**From:** Karl Roberts  
**Sent:** 04 September 2019 14:18  
**To:** [REDACTED]  
**Cc:** Planning Scanning  
**Subject:** Planning application A/100/19/PL - Arundel Acre, Angmering

- The applicant will need to provide a plan to demonstrate that the appropriate visibility splays can be achieved to and from the site access and around the corner radius from the westbound A27 into the B2225 Arundel Road to the access in accordance with the minimum Stopping Sight Distance in *DMRB TD9/93 Highway Link Design* and *DMRB TD41/95 Vehicular Access to All Purpose Trunk Roads*. If this is not achievable and

Title REVISED ACCESS LOCATION AND ACHIEVABLE VISIBILITY SPLAYS

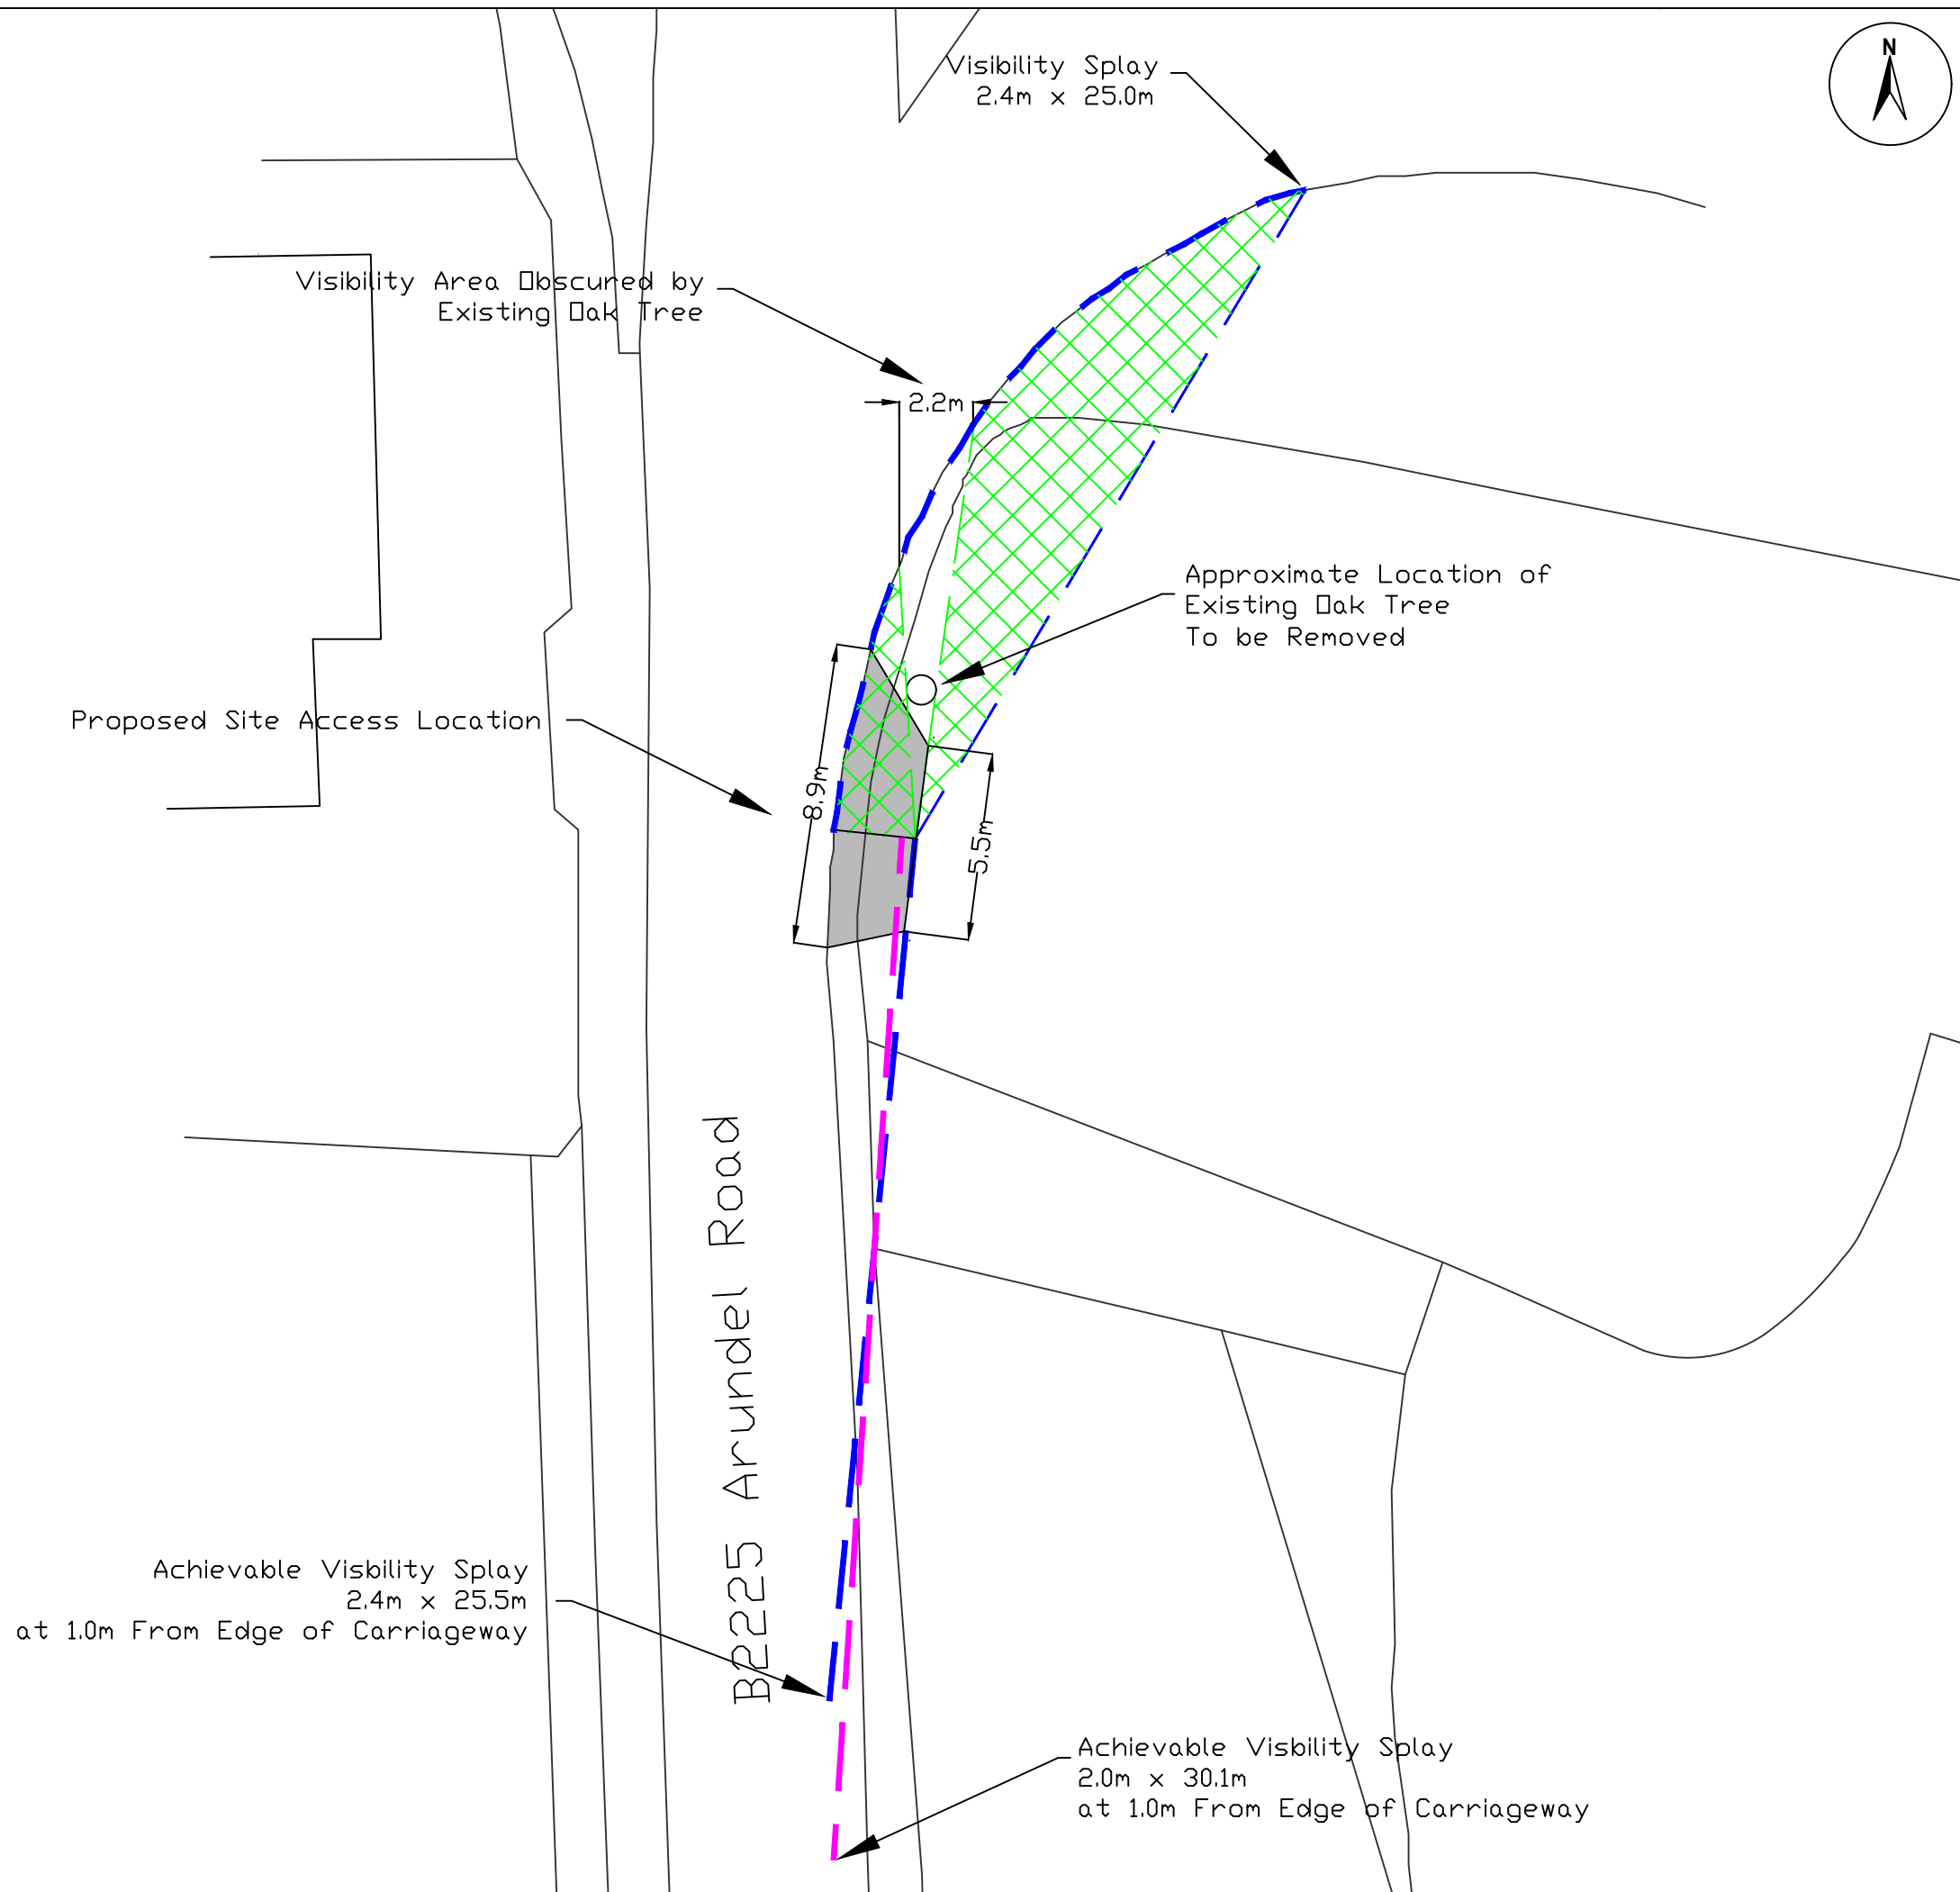
therefore cannot be robustly demonstrated. Highways England will be required to recommend refusal of the application because of the potential detriment to road safety.

I would be grateful if you could confirm within 7 days if it is your clients intention to provide a plan showing the required visibility splays (notice will also need be served if appropriate). If it is the intention to provide such a plan I would ask that it be submitted within 21 days from the date of this email. Once received we will re-consult Highways England and any other party considered necessary.
